31 July 2026

Request for Additional Information – Western Sydney University Indigenous Centre of Excellence SSD-64916225

2 DA NORTH ELEVATION
1 : 200

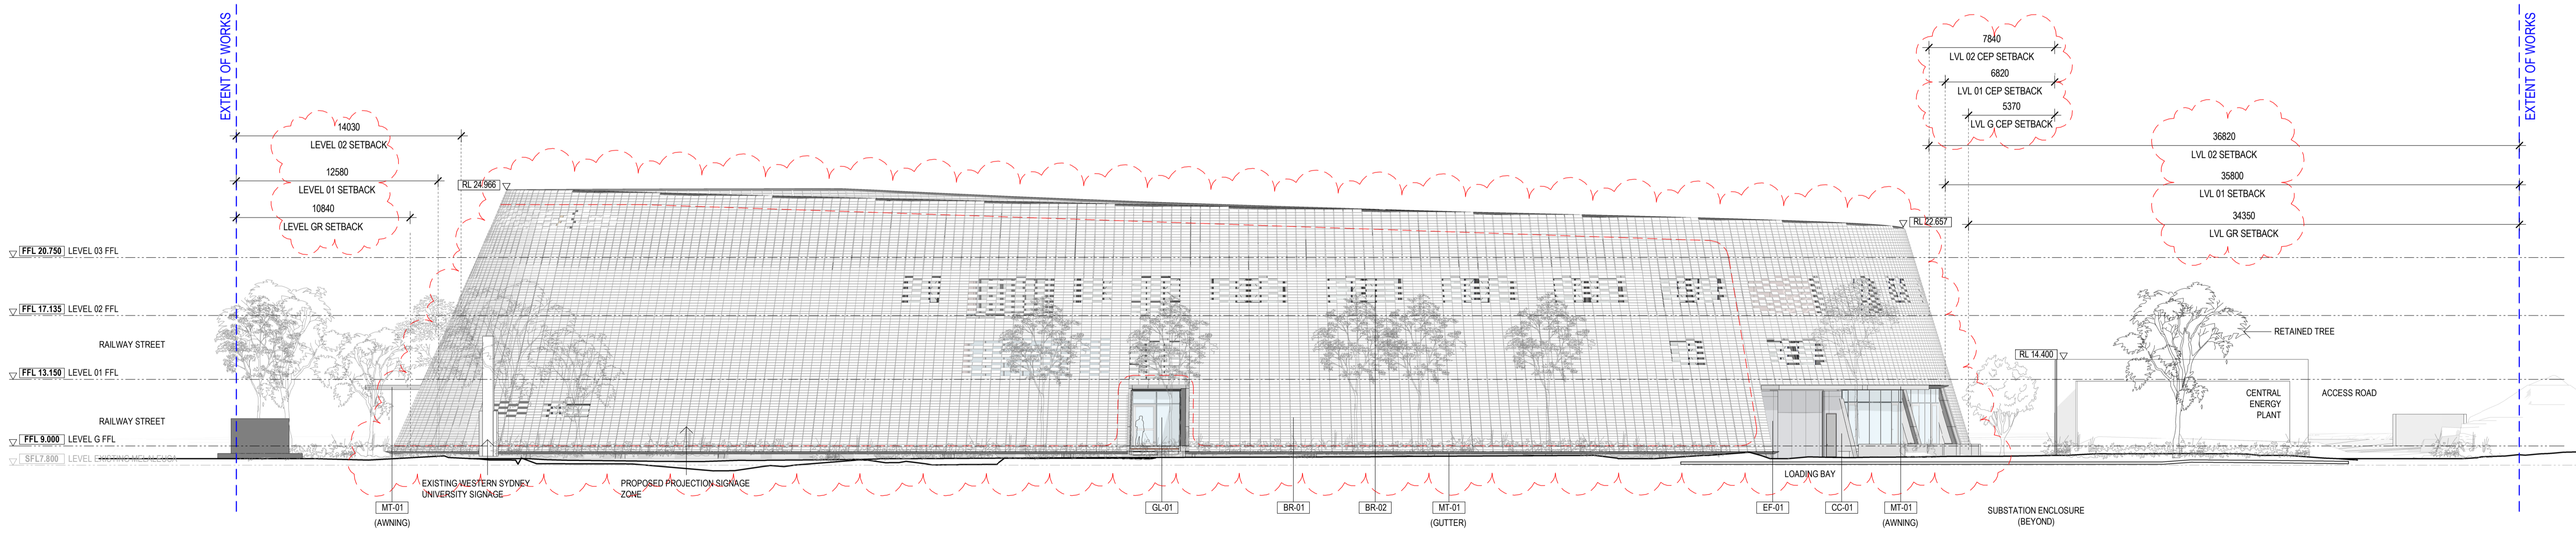
Council acknowledges and supports the effort of enhancing the sense of arrival from Victoria Road which provides better building address to the main street and more street prominence. However, as previously commented, the proposed form still offers little activation to this primary road. Acknowledging the noise constraints of such a busy road, it is still considered valuable for the proposal to address this frontage and respond to the street with a more significant entry point. Improved permeability from Victoria Road into the site would be achieved through a more distinctive primary entry (that opens into the internal space with more generous dimensions). 'Opening up' of the Victoria Road façade through a horizontal ground floor glazing opening, similar to the interface with the internal courtyard, would provide sightlines into the centre.

Response: An Urban Design Response was provided to DPHI on 18 February 2026. See **Attachment D**.
